CITY OF ALBUQUERQUE

Re: Smith's Fuel Center # 446, 6301 Lomas Blvd NE,
Request for Permanent C.O. - Approved
Engineer's Stamp dated: 6-08-09 (J-18/D015)
Certification dated: 02-08-11

Based upon the information provided in the Certification received 02-09-11, the above referenced Certification is approved for a release of a Permanent Certificate of Occupancy by Hydrology.

Grading Plan

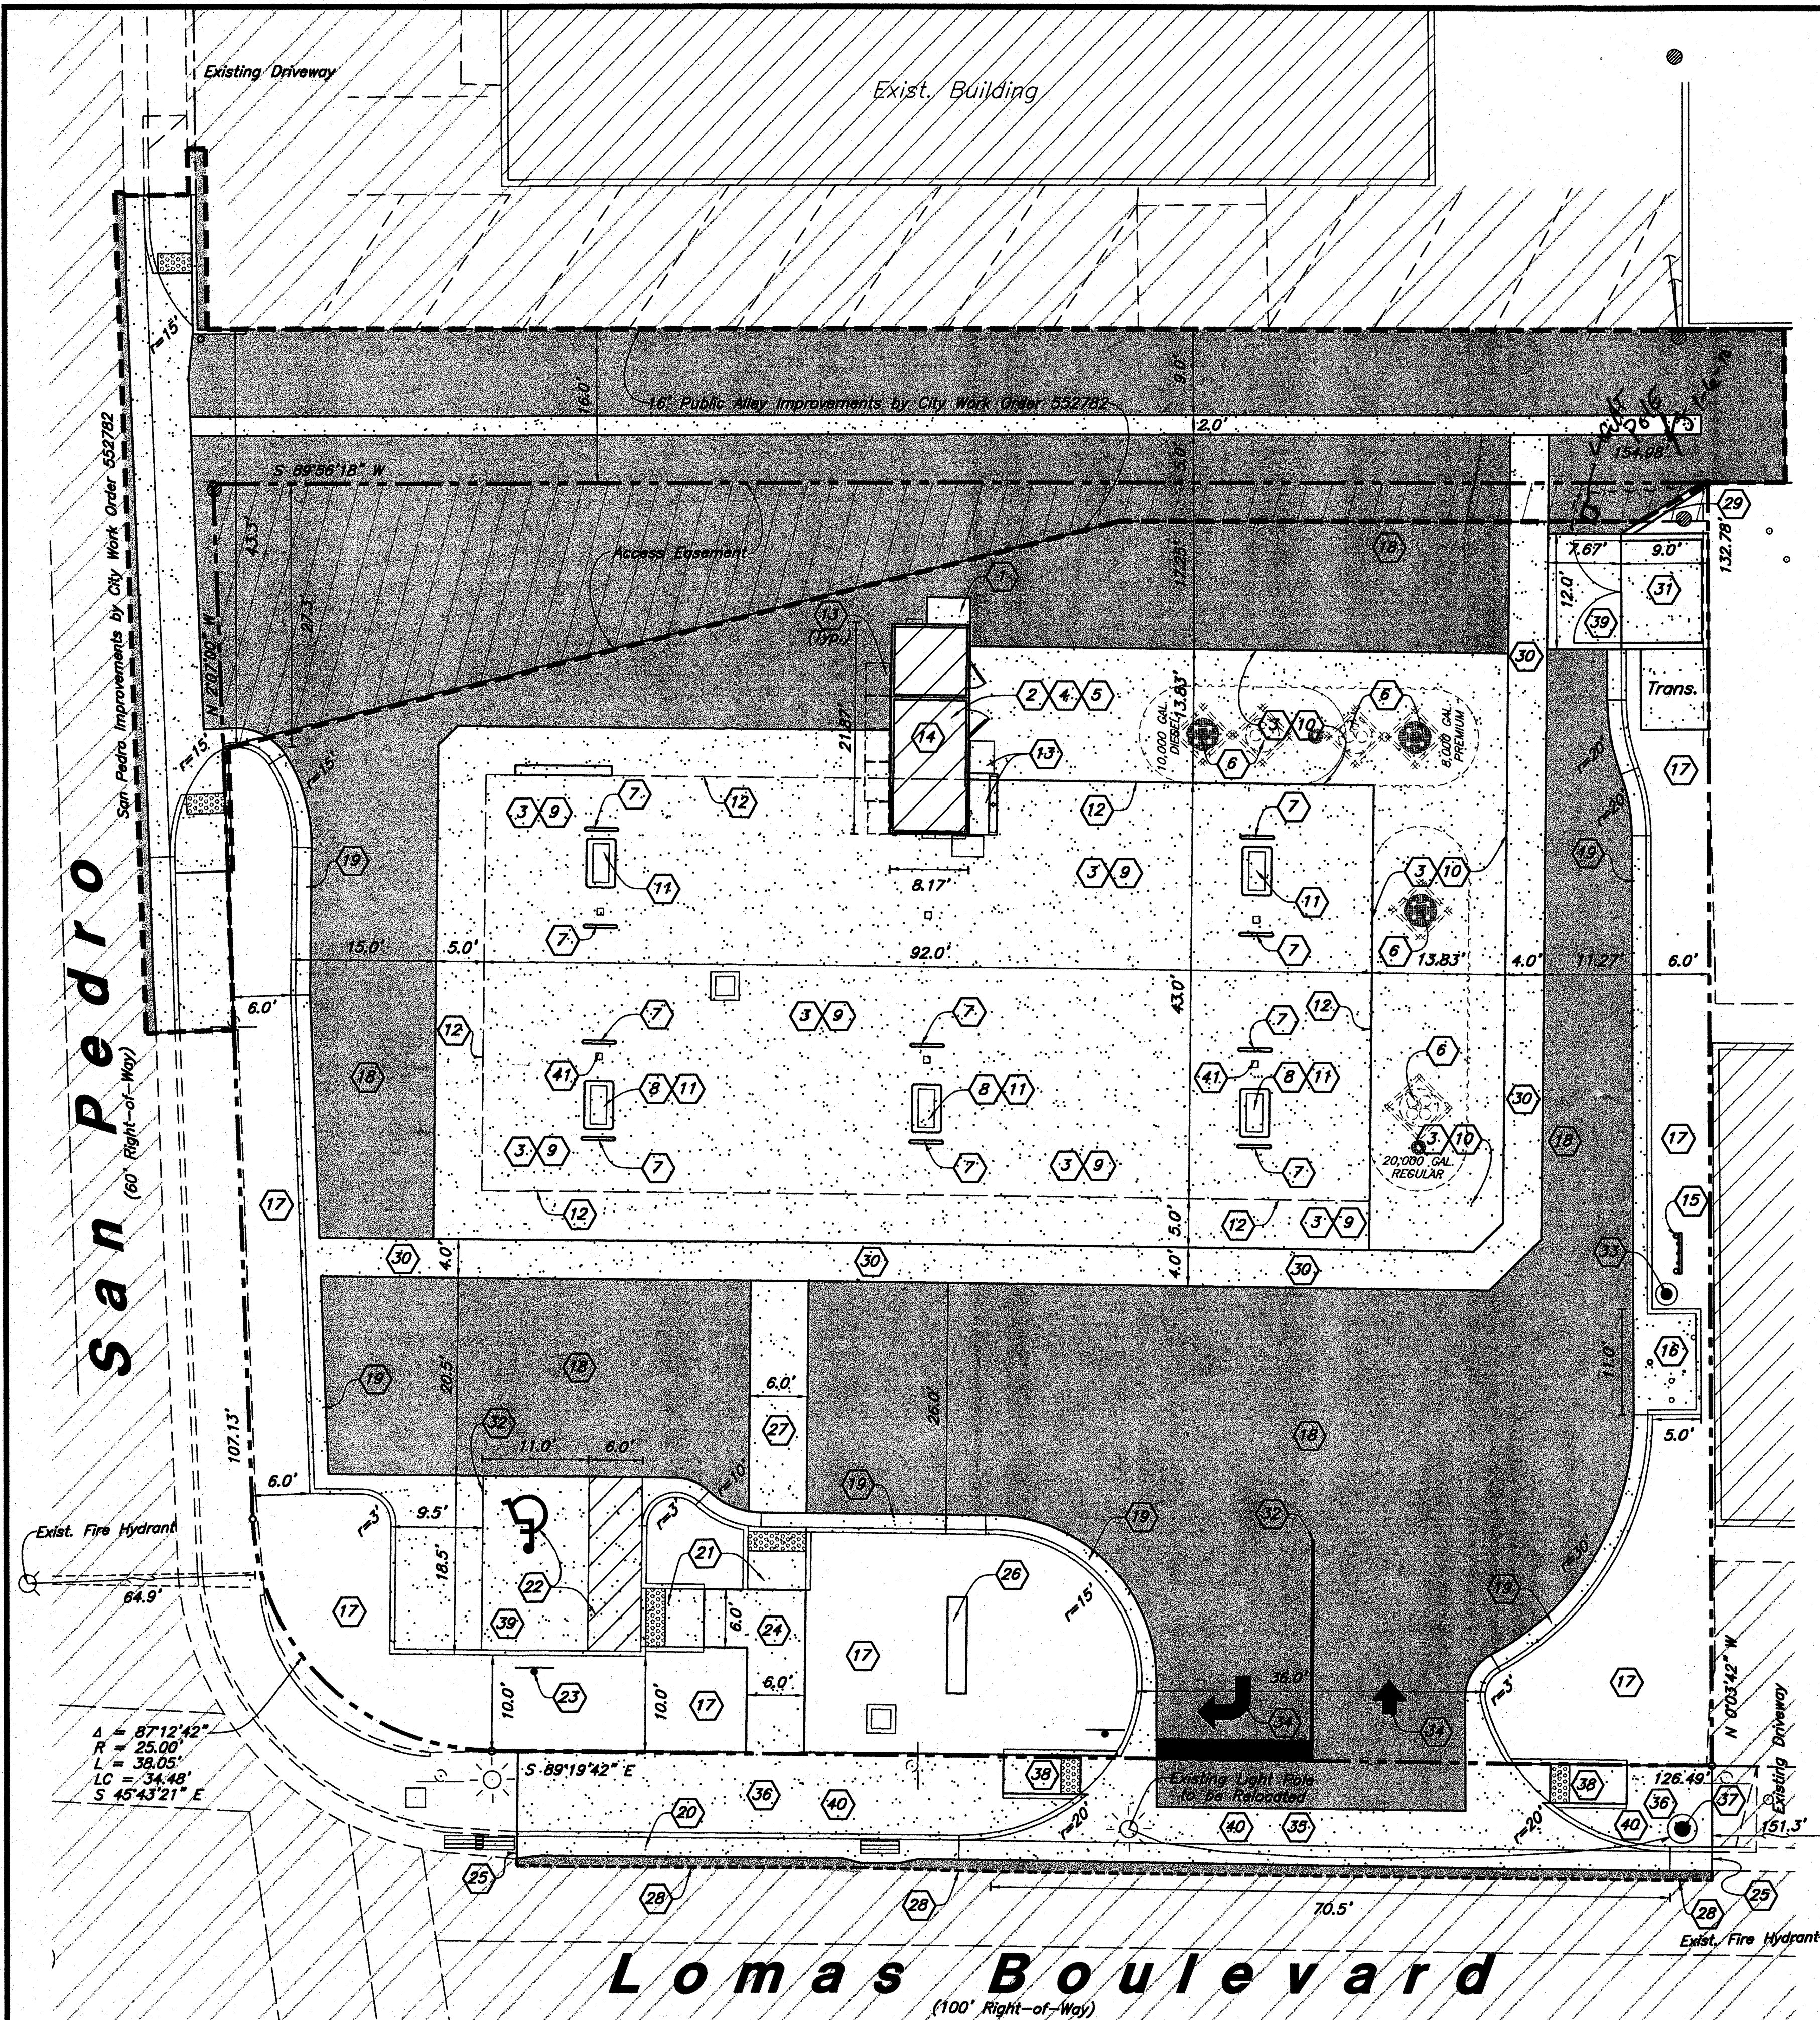
- ✓ The water block on the Lomas Blvd entrance needs to be increased because the HGL in Lomas Blvd is at/near top of curb in this location and the Finished Floor of the building is below the flow line in Lomas Blvd. The water block should be built to a minimum of 78.00 to keep the storm water in the street.
- ✓ As discussed with Kirk Randall, a check valve should be built on private property in the 8" storm drain upstream of the inlet you are connecting to.
- ✓ Provide two copies of Sheet C3.1. We give one to our inspector.
- ✓ The SO 19 Permit is for minor storm drain work in the ROW. In this instance it is for tying into the back of the inlet.

- The water block on the Lomas Blvd entrance needs to be increased because the HGL in Lomas Blvd is at/near top of curb in this location and the Finished Floor of the building is below the flow line in Lomas Blvd. The water block should be built to a minimum of 78.00 to keep the storm water in the street.
- As discussed with Kirk Randall, a check valve should be built on private property in the 8" storm drain upstream of the inlet you are connecting to.
- Provide two copies of Sheet C3.1. We give one to our inspector.
- The SO 19 Permit is for minor storm drain work in the ROW. In this instance it is for tying into the back of the inlet.

Site Plan
Smith's Fuel Center #446
6301 Lomas Boulevard, NE
Albuquerque, New Mexico

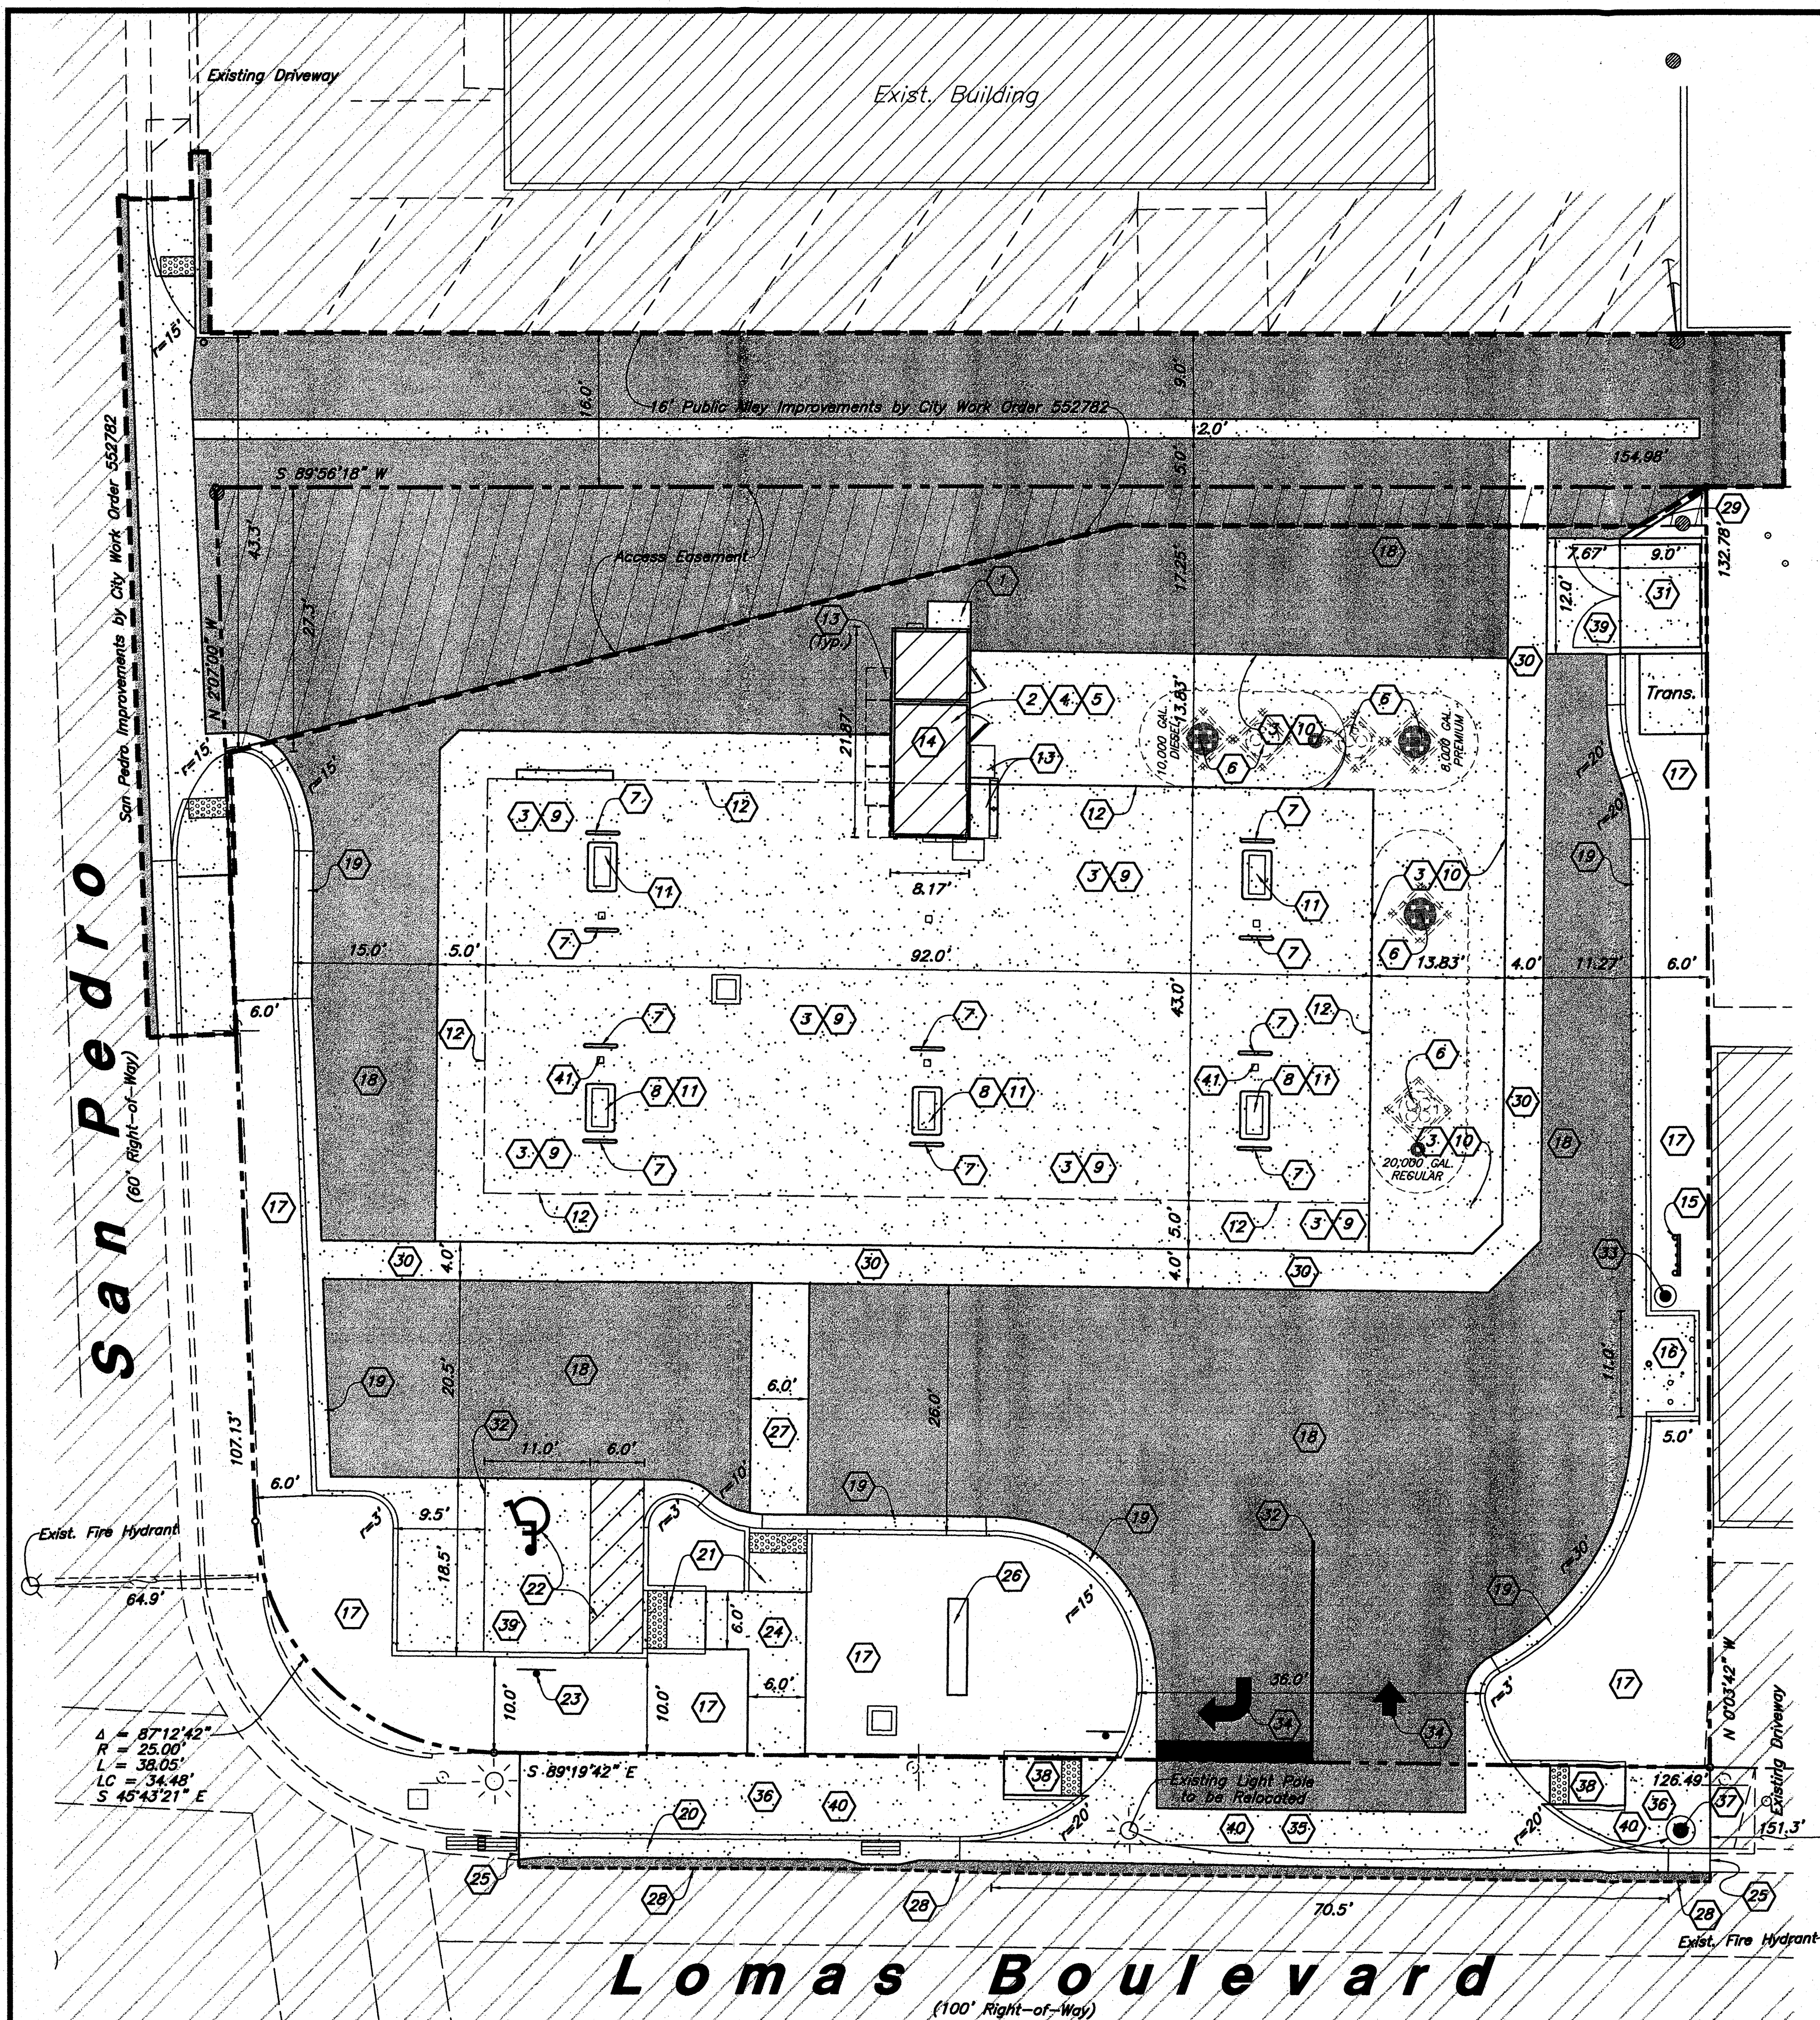
- ✓ 1. List the number of parking spaces required by the zoning code as well as the proposed number of parking spaces.
- ✓ 2. A six-foot wide, ADA accessible pathway must be provided from the handicapped spaces to the building.

- ✓ 3. Clearly define what items are to be built by city work order (CPN 552782) and what items are to be built with the building permit. Based upon the current plans on file, the alley and San Pedro improvements are to be built under the work order, and all other items are to be built with the building permit. Remove all build notes from the building permit submittal that are to be built under work order and add a note defining this.

- ✓ 6. Add a note regarding the removal of the existing curb cut along Lomas Boulevard and its replacement with sidewalk and curb and gutter. Refer to City Standards 2415 and 2430.

- ✓ 7. All sidewalk located within City right of way must have truncated domes.
- ✓ 8. Keyed note 32 indicates proposed striping within the public access easement. Please remove all striping from the public access easement.

- ✓ 9. Include all items regarding traffic circulation (dimensions, build notes, keyed notes, etc.) on one sheet.
- ✓ 10. Per the *Development Process Manual*, Chapter 23, Section 6, Part B.5, a 20-foot minimum radius is required at the flowline for passenger vehicles. As your site appears to anticipate significant heavy vehicle traffic, a larger radius is recommended.

- ✓ 11. Provide additional information regarding the light pole relocation (keyed note 37). Why is this pole being relocated? Where is the existing pole located?
- ✓ 12. Please show the location of the nearest driveway on the adjacent lot. Proposed improvements appear to interfere with the existing curb cut on the adjacent lot along San Pedro.
- ✓ 13. Provide additional information regarding keyed note 40; why place a post here?
14. Prior to certificate of occupancy approval, the following items must be completed:
 - **A recorded copy of the public roadway easement must be included for our files.**
 - **The work order along the alley (CPN 552782) must be completed and closed out.**

Contraction Joint

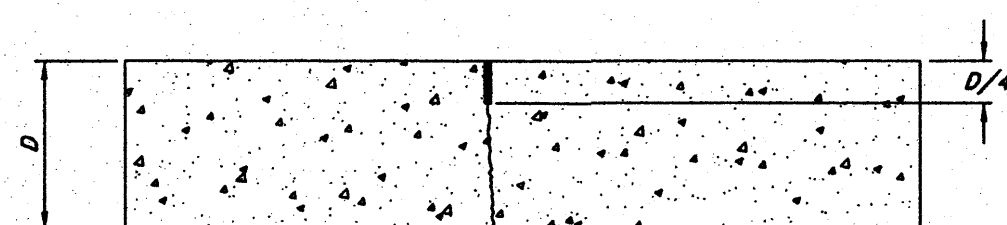
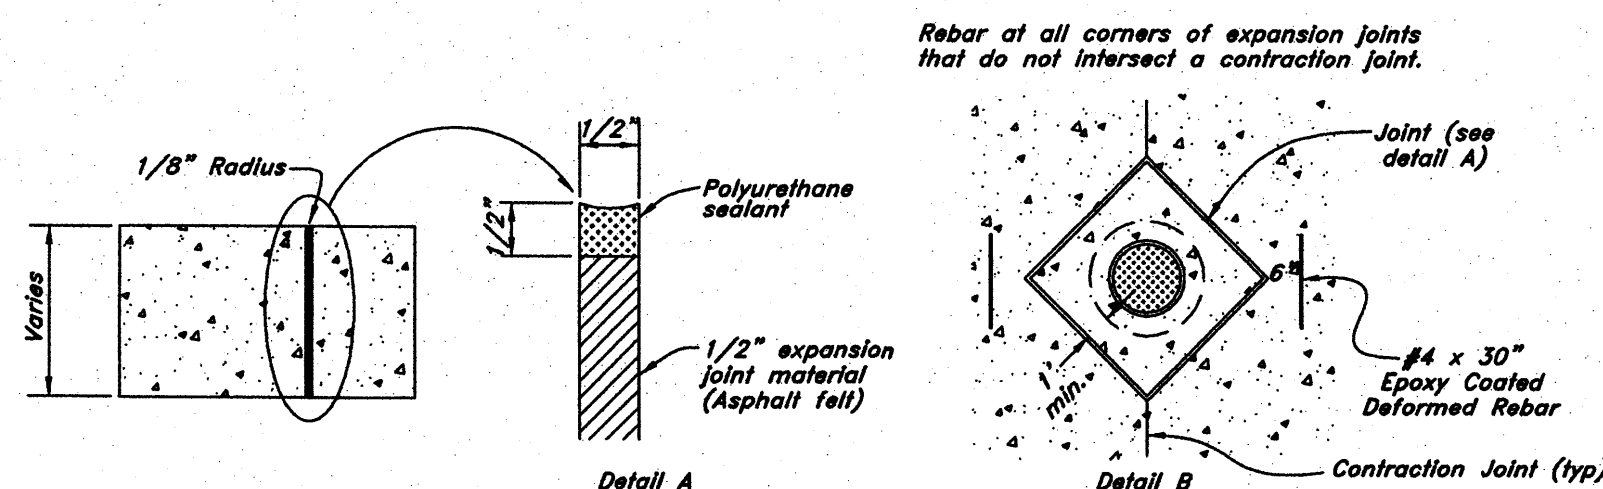
Per our inspection of the valley gutter and curb and gutter along Lomas Boulevard on Dec. 15, 2009 it was determined that the necessary expansion joints and contraction joints were not constructed. Three (3) expansion joints located where new curb and gutter abuts existing curb and gutter near the existing catch basins will be installed by saw cutting a 1/2" gap completely through the curb and gutter and inserting the expansion material. Contraction joints will be installed by saw cutting a minimum of 1" deep at 12' max. spacing per detail 2415A.
